# City of Albuquerque Stormwater Construction Site Inspection Report

Project Name and Location	Commercial + Art Bldg ph2 4th & Freeman		
Site Contact Name & Agency	Jose Rodriguez	ESC File No.	614E066
Date of Inspection	1-8-18	Start/End Time	9:20 / 1:25
Inspector Name, COA Dept.	Curtis Cherne, Stormwater Quality		
Describe Present Phase of Construction	Stabilized		
Type of Inspection:	<input checked="" type="radio"/> Regular    • During storm event    • Post-storm event (> 0.5 inch)    • 311 / Complaint Response    • Follow-Up

**From:** Cherne, Curtis  
**Sent:** Friday, June 16, 2017 3:28 PM  
**To:** 'rodriguez3003@hotmail.com'  
**Subject:** Fourth and Freeman project Construction site inspection  
**Attachments:** cement\_pollution.jpg; track-out\_pad.jpg

Concrete Washout Area For use in High Water Table Areas

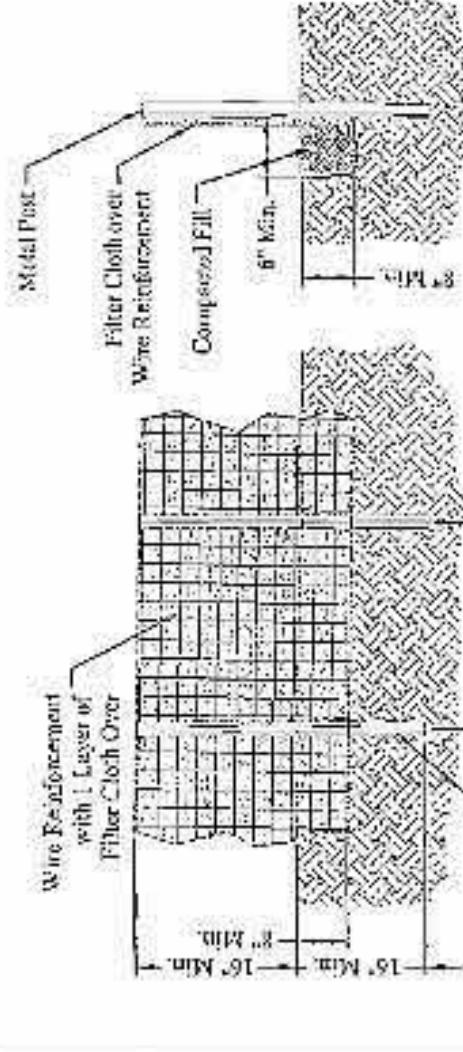
Jose,  
Good afternoon,  
I went out to the project today.  
Someone washed-out in the pond and I did not see an acceptable wash-out facility onsite. Please remove cement pollution and bring in an acceptable wash-out. Due to site constraints an Outpak or two may be the answer.

1. Duke City was washing out there truck when I pulled up. I spoke to the driver. He informed me that the Site Supervisor told him to wash-out there. Wash-out is to be in a lined pit or wash-out bin. I didn't see an appropriate wash-out location at the site.
2. The entrance needs maintenance and there was track-out. This area of 5<sup>th</sup> street is to be swept.
3. The inlet at 5<sup>th</sup> and Freeman should have acceptable inlet protection. A wattle or mulch sock would be acceptable.
4. There was another wash-out on Freeman St. For some reason the trash on top of it makes it stand out more.

Stabilized Construction Entrance

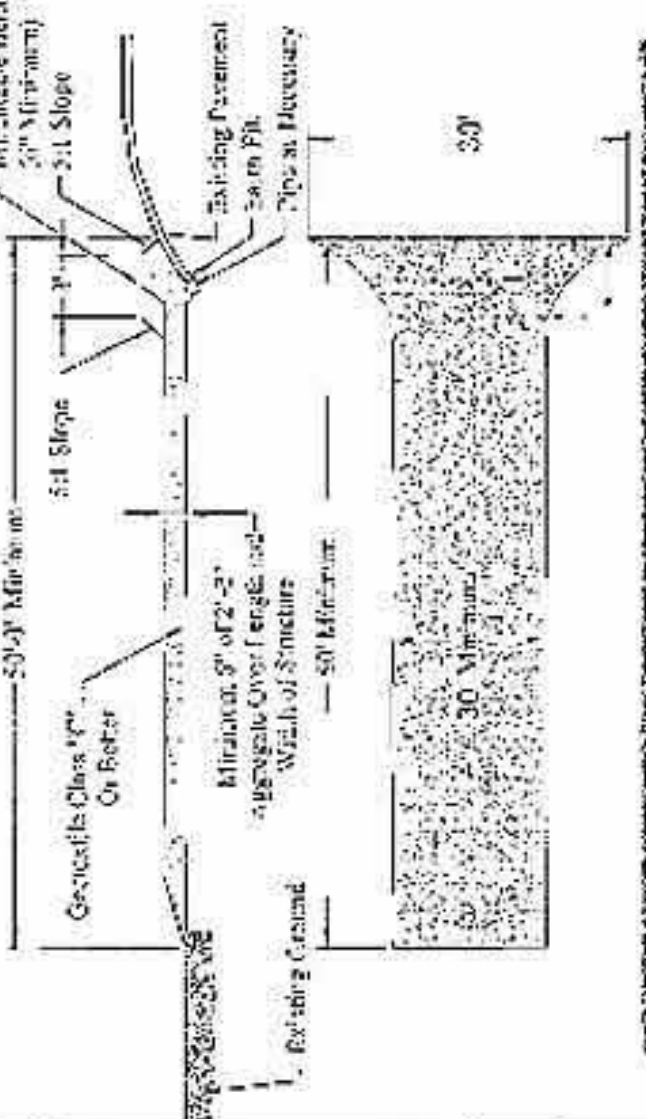
Jose,  
I visited the construction site at 4<sup>th</sup> and Freeman on Wednesday. The silt fence looked good and there was no trash. However, you need to put in a stabilized rock construction entrance (see ESC plan from Inspections plus) and the site wasn't posted per paragraph 1.5 of the CGP.

- Entrance / Off Tracking NO Construction entrance 1 minor track out
- Sediment Controls / Silt Fence, Check Dams, Waddles, etc. OK
- Erosion Controls / Mulch, Seed, NO
- Wind Blown Erosion NO
- Housekeeping / Pollutant Controls good
- NO posting Sign
